Your Ref: OWPC21908
Our Ref: BR/49/19/OUT 13-02-2019
Please ask for:
Mr S Davis

Outline application with all matters reserved for 22 No. new dwellings consisting of 2 No. 1 bed dwellings, 18 No. 2 bed dwellings & 2 No. 3 bed dwellings.

26 Burnham Avenue Bognor Regis

Thank you for your internet representation made on 30th March 2019 which has been recorded as '**an objection**' with the comments as follows:

South Elevation (Proposed) 1:100
0 2.5 5.0 M

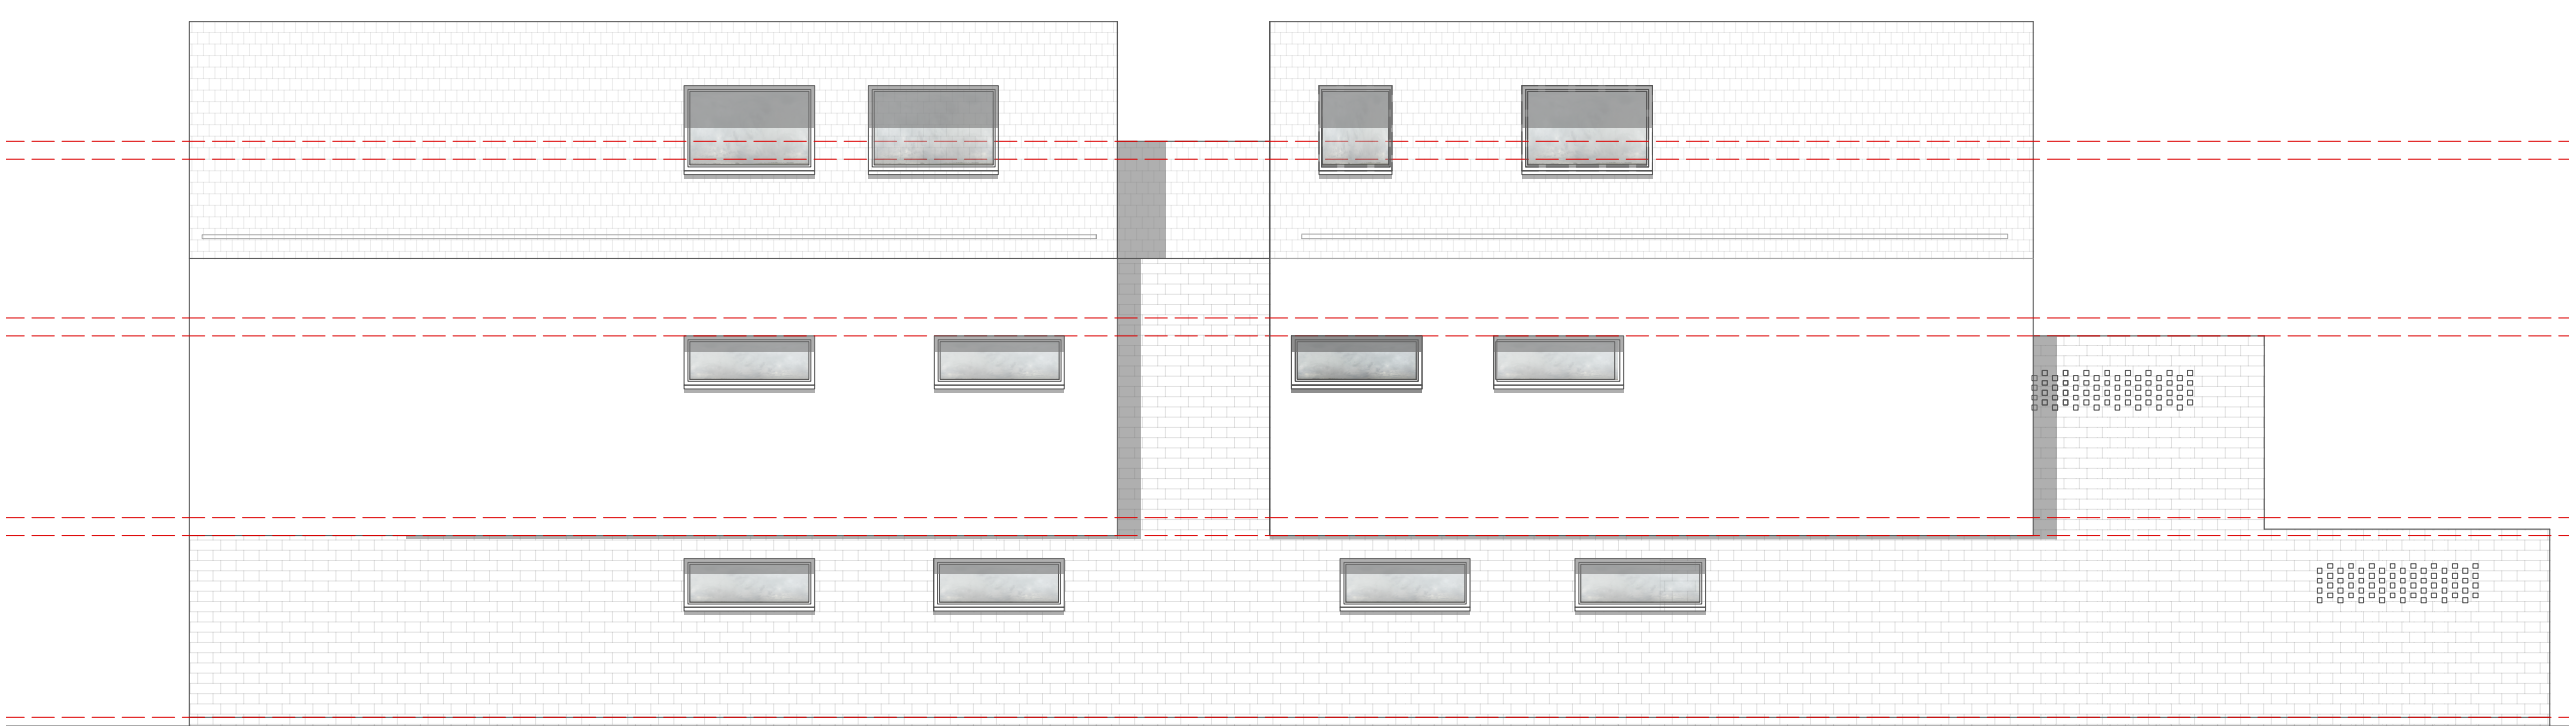
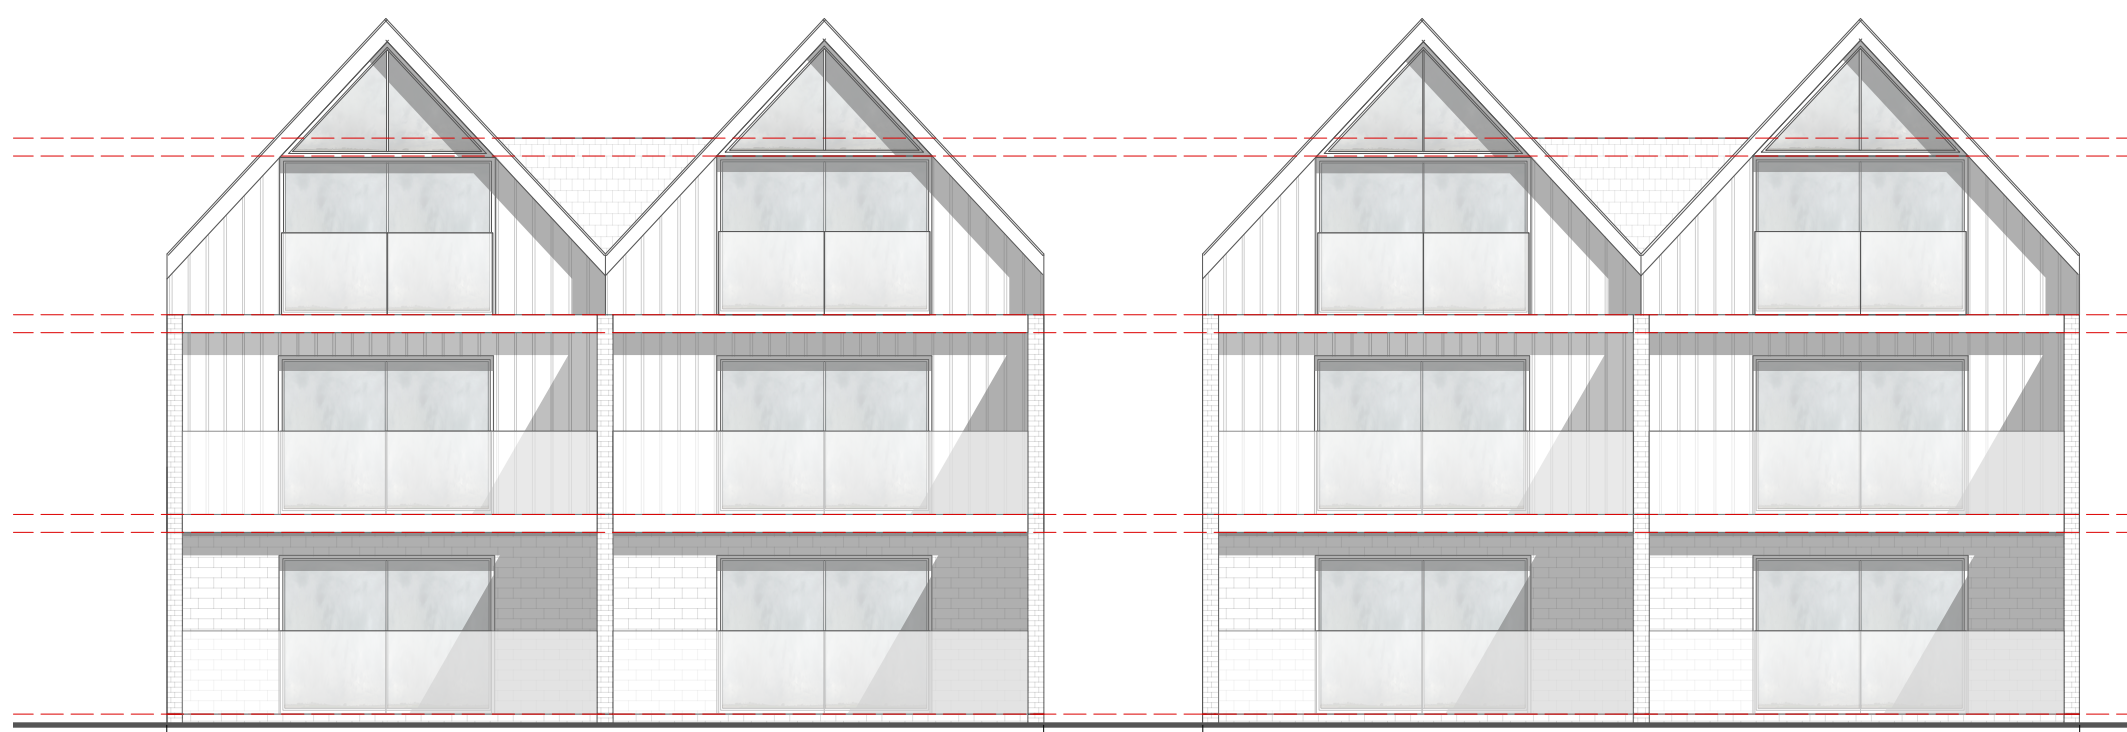
5. Safe access for the fire service does not appear to have been provided, due consideration should also be given to the block of flats visible from the plot but not shown in the plans as the increase in population density as well as fire risk from adding so many dwellings is also relevant.

Streetscape (Proposed) 1:100
0 2.5 5.0 M

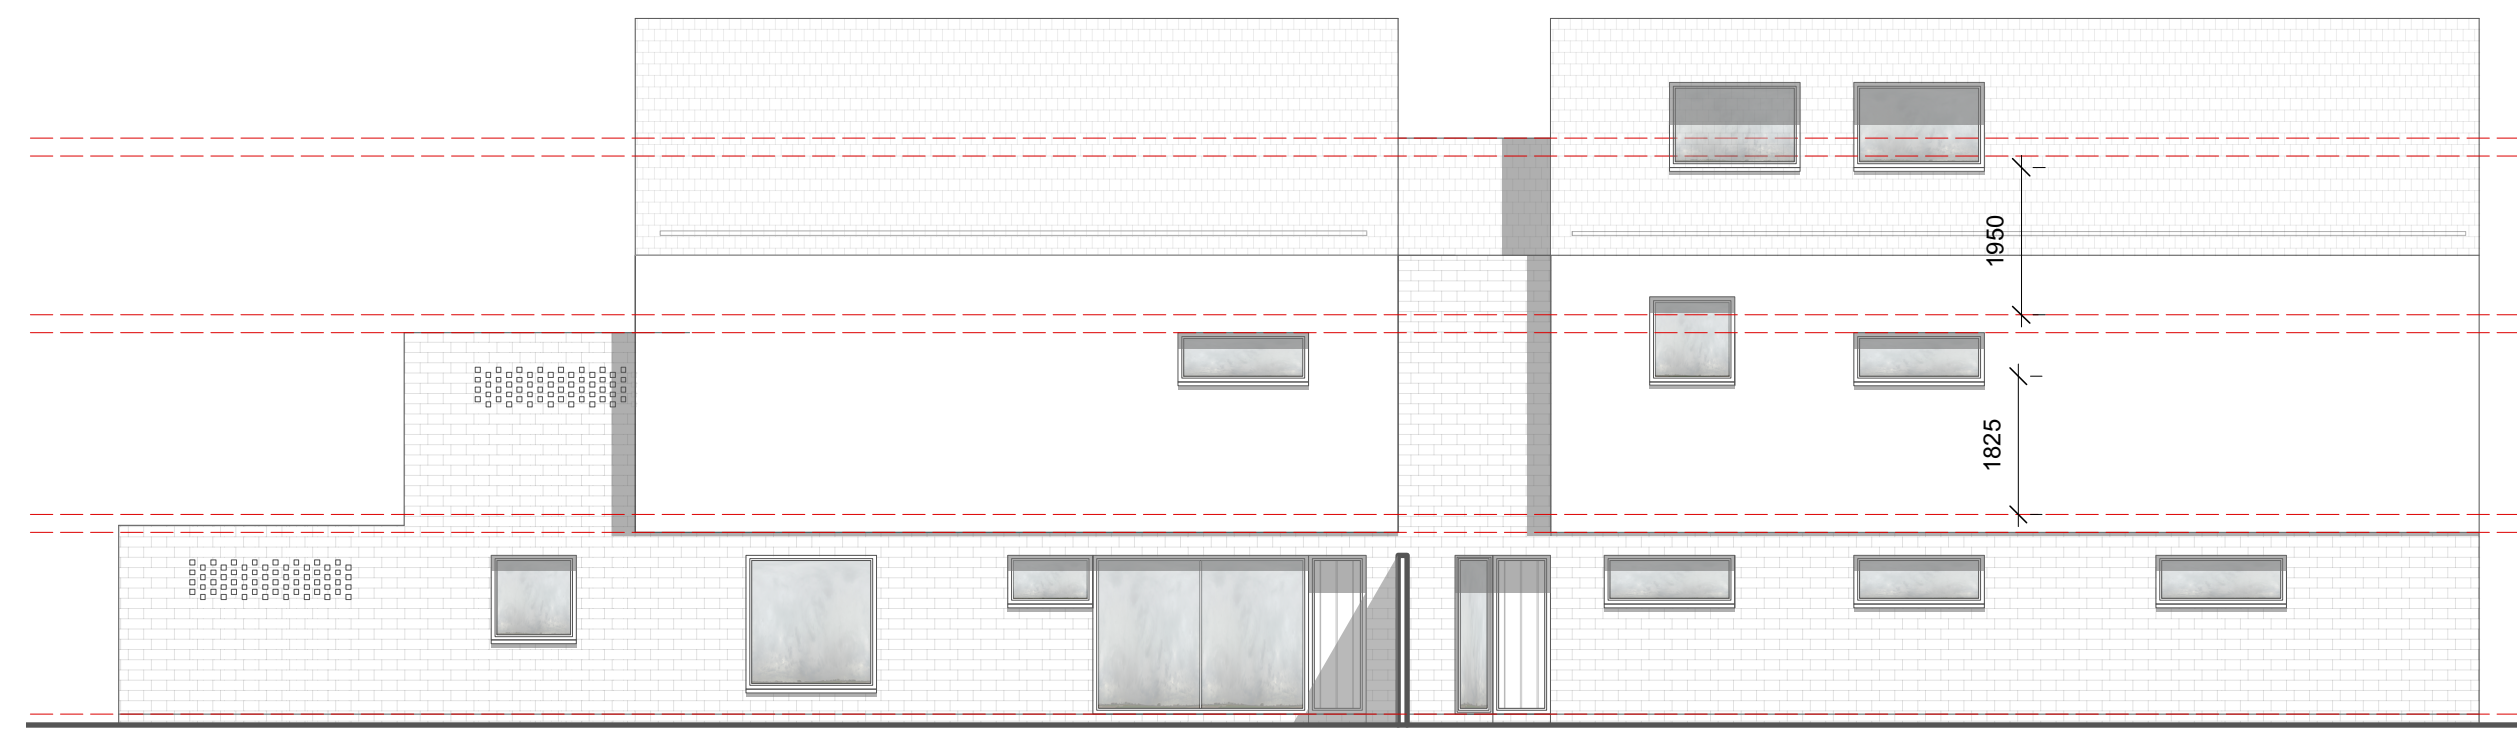
- 3. The scale and type of development is completely out of step with the residential road in which it is proposed, which consists of detached and terraced houses; there are no other developments of this type - probably because it is unsuitable and out of character.*

8. The size of the construction and overlooking, particularly of the neighbouring detached and and bungalow means there is a good chance this development will prevent the occupants going about their day-to-day business unaffected by the development.
